SHOPS AT MCLAUGHLIN II

7368 McLaughlin Road, Peyton CO 80831

DEVELOPMENT PLAN

# Markup Summary

1 of 10 SITE  
PLAN

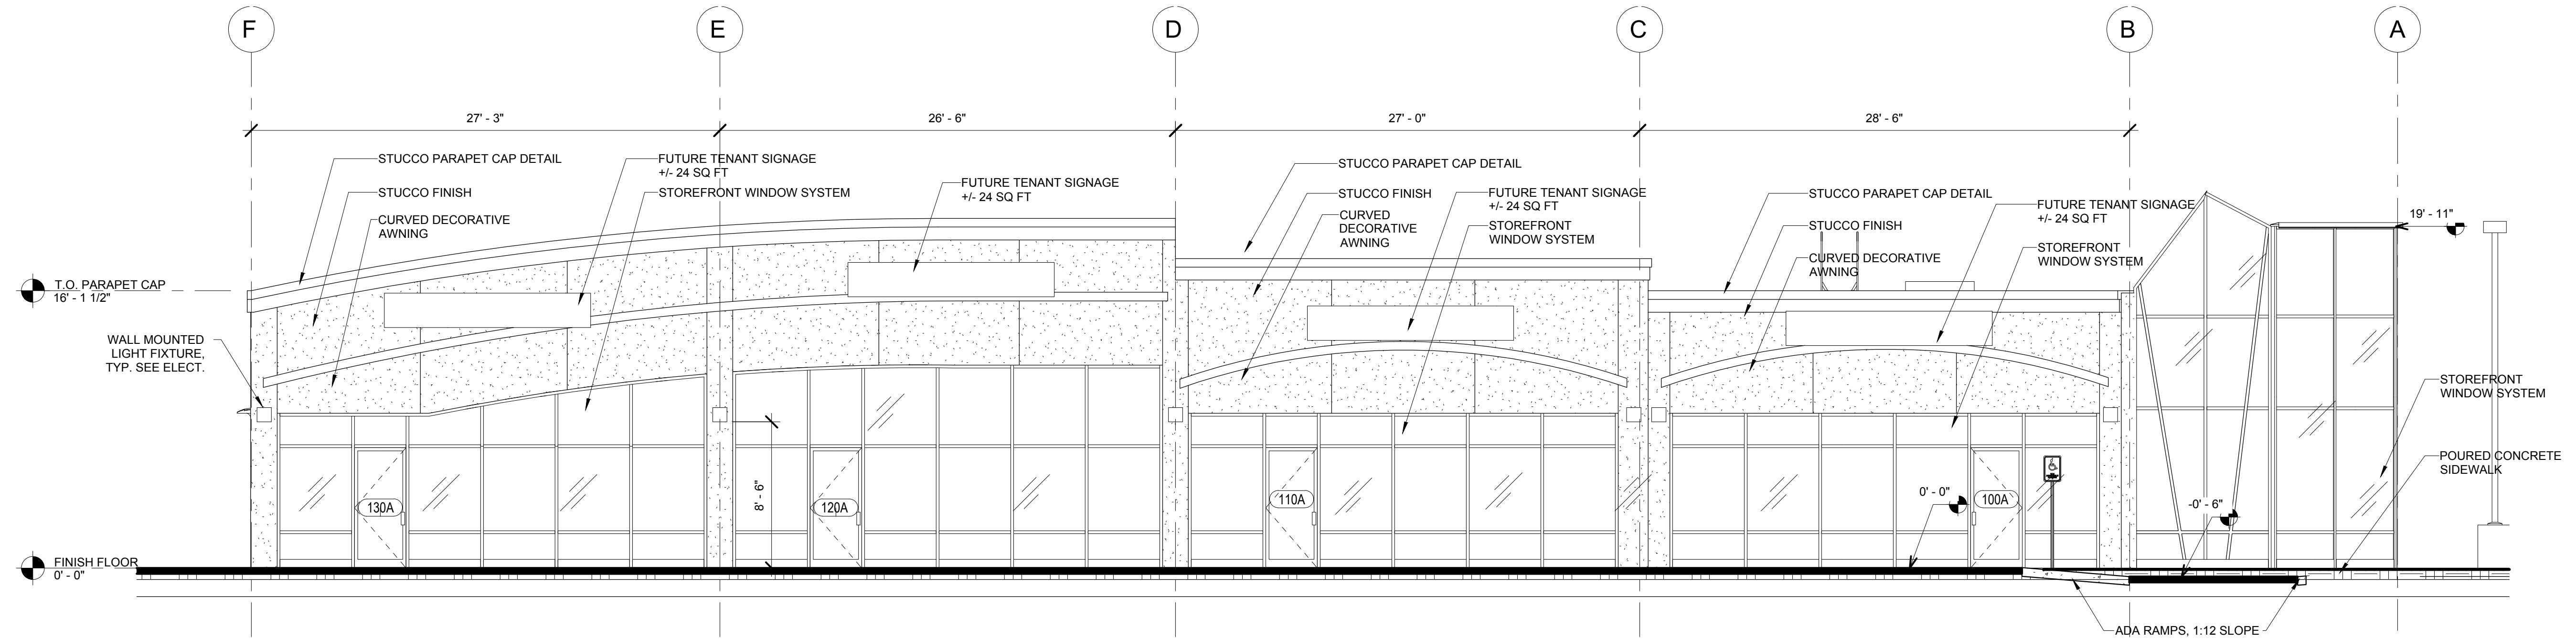
New county standards require an ADA note and route to be included on the Site Development Plan. The following is the correct template for the note:

"The parties responsible for this plan have familiarized themselves with all current accessibility criteria and specifications and the proposed plan reflects all site elements required by the applicable ADA design standards and guidelines as published by the United States Department of Justice. Approval of this plan by El Paso County does not assure compliance with the ADA or any regulations or guidelines enacted or promulgated under or with respect to such laws."

Each site development plan or non-residential site plan submitted to El Paso County shall clearly illustrate and identify the provision of ADA accessible exterior routes in accordance with the applicable ADA design standards and guidelines as published by the United States Department of Justice

dead space, suggested to move dumpster location here and move loading area to allow for more parking, also will allow trash truck to maneuver without blocking parking and damaging parking lot

Where is sidewalk and curb ramps? Also Sidewalk needs to be continued to property line.

Table 6.4 of the LDC requires a parking space with 0 degrees to have a minimal depth of 22 feet

Not indicated on site plan

Not indicated on plan at perimeter

General Retail is 1 for 250 square feet. Based on suggested uses, highest standard must be met. Required parking is 24 parking spaces. Letter of Intent should address any modification request. Letter of Intent should also indicate there will be no restaurants at location. as restaurants are 1 parking per 100 square feet.

Inadequate design, a curb cut must be provided to allow maneuvers to back up, see Starbucks at Academy Gateway for approved plans.

2 of 11 SITE
DETAILS

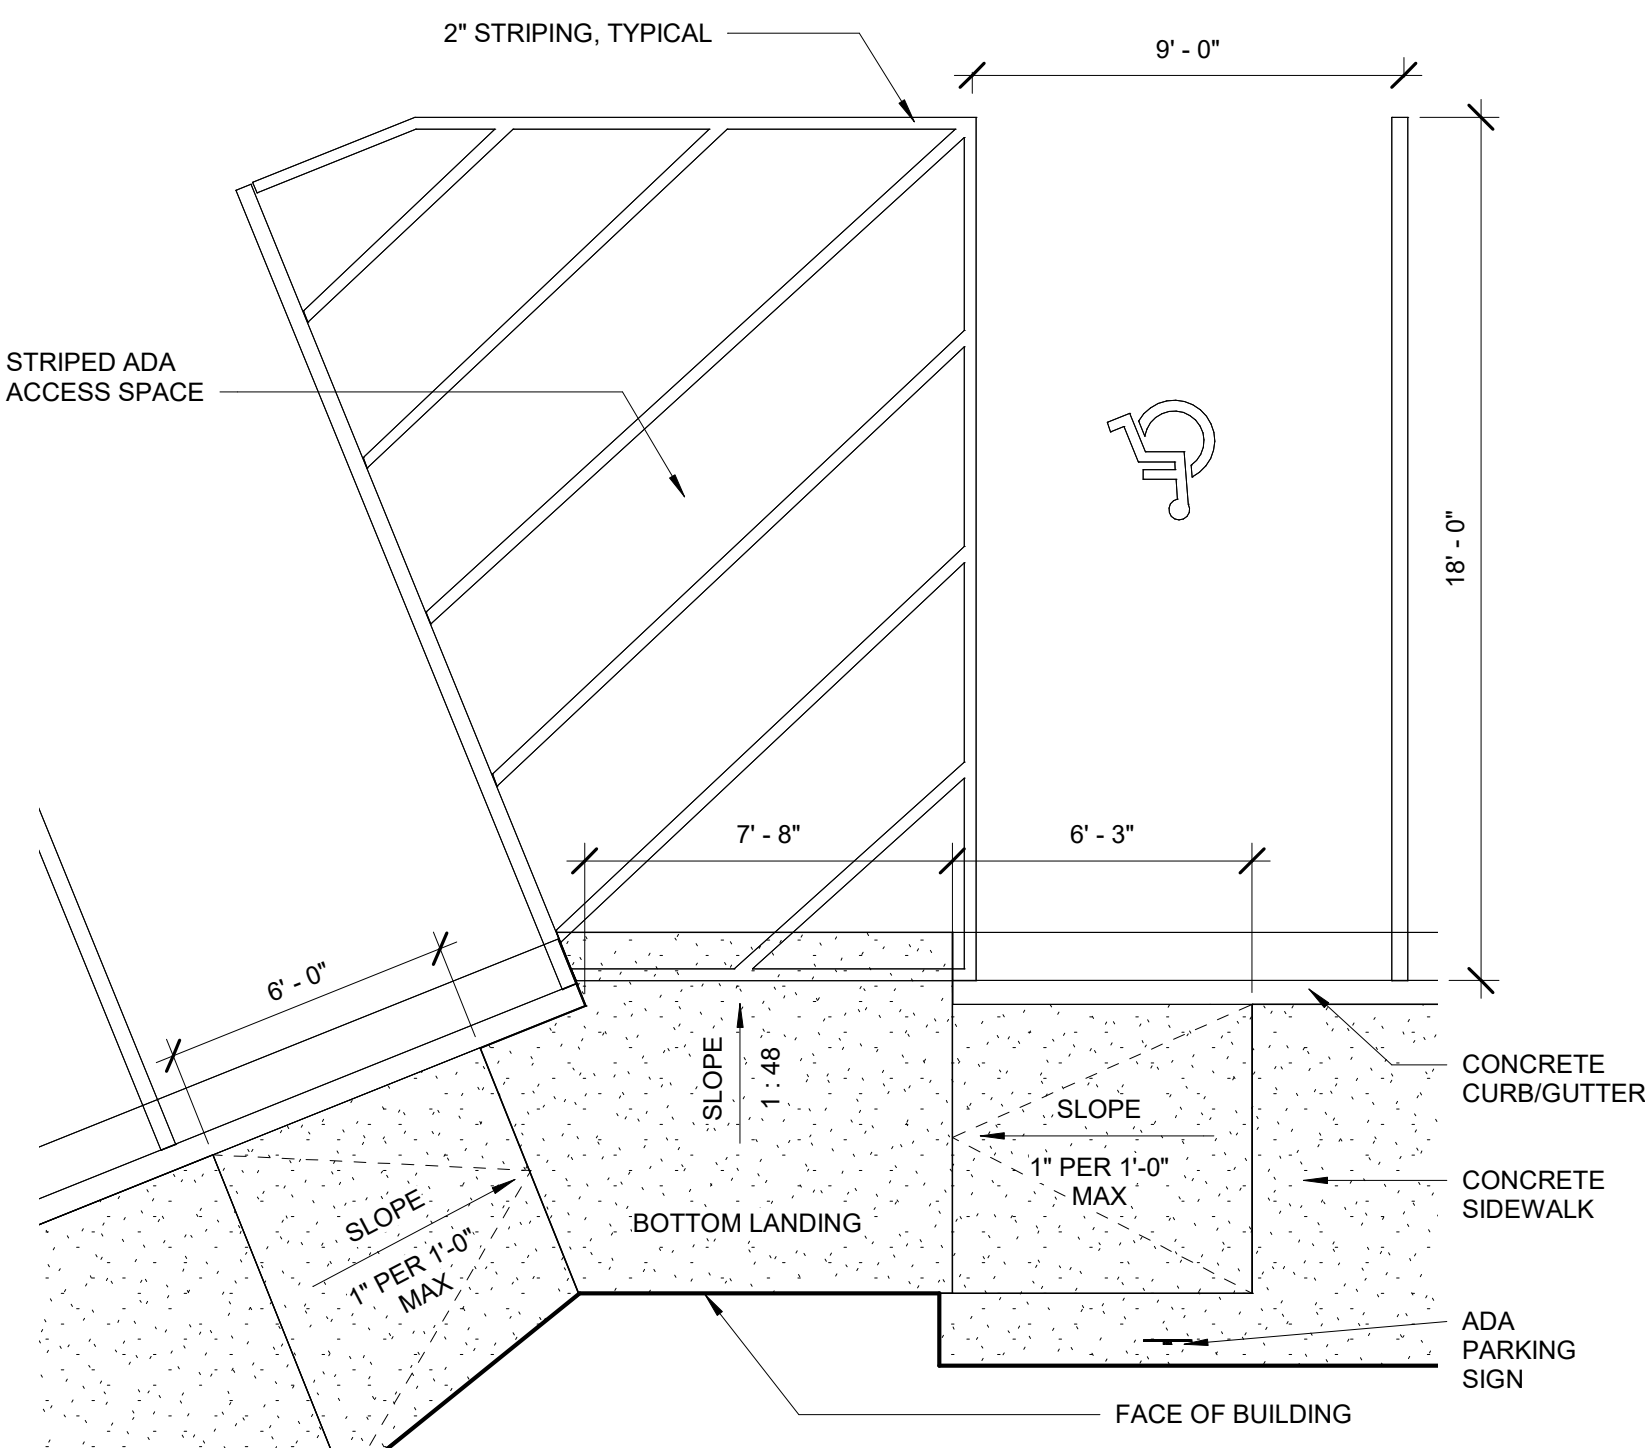
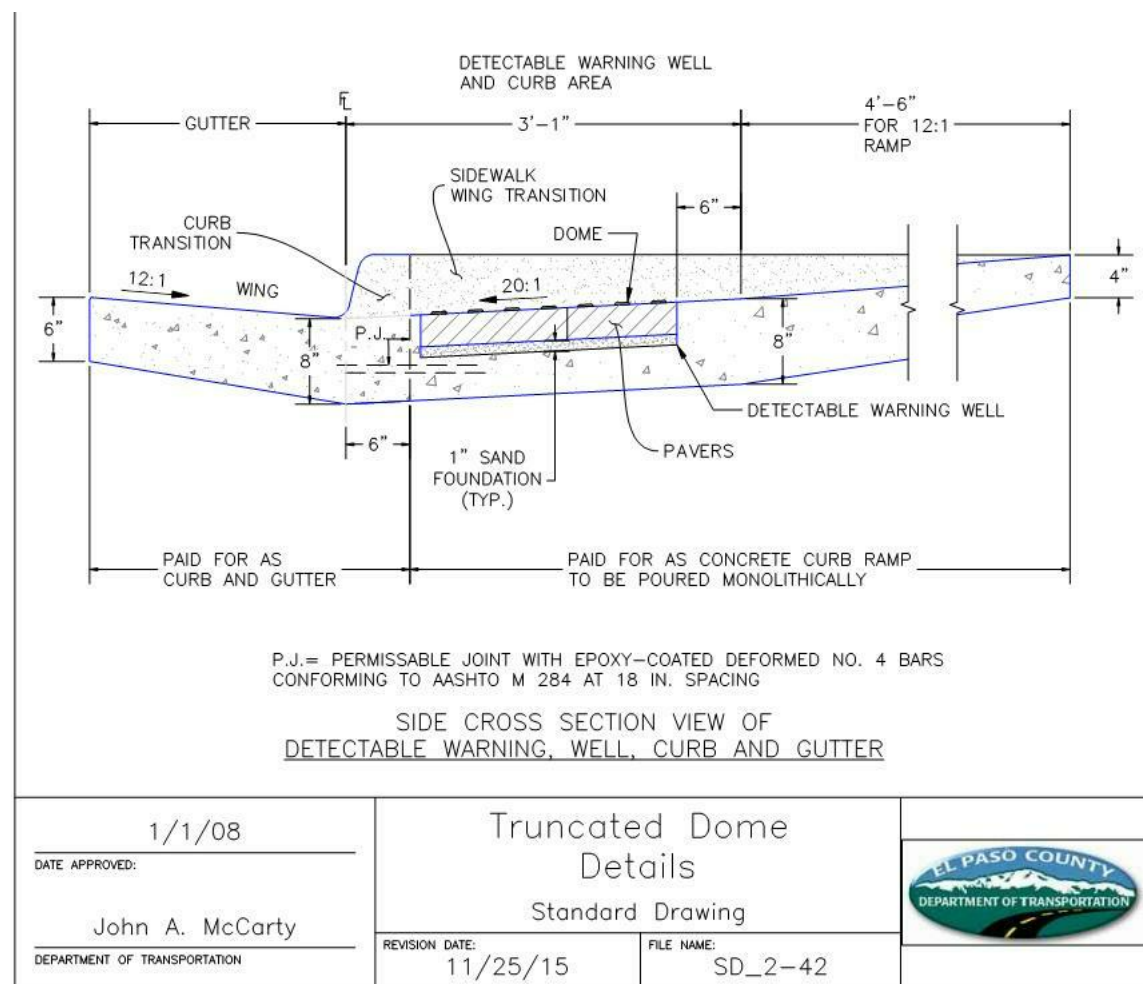
Include details for the following items:  
#3, 7, 14, 10 (Drive Pan).

ADA curb ramps also need to be included on detail page.
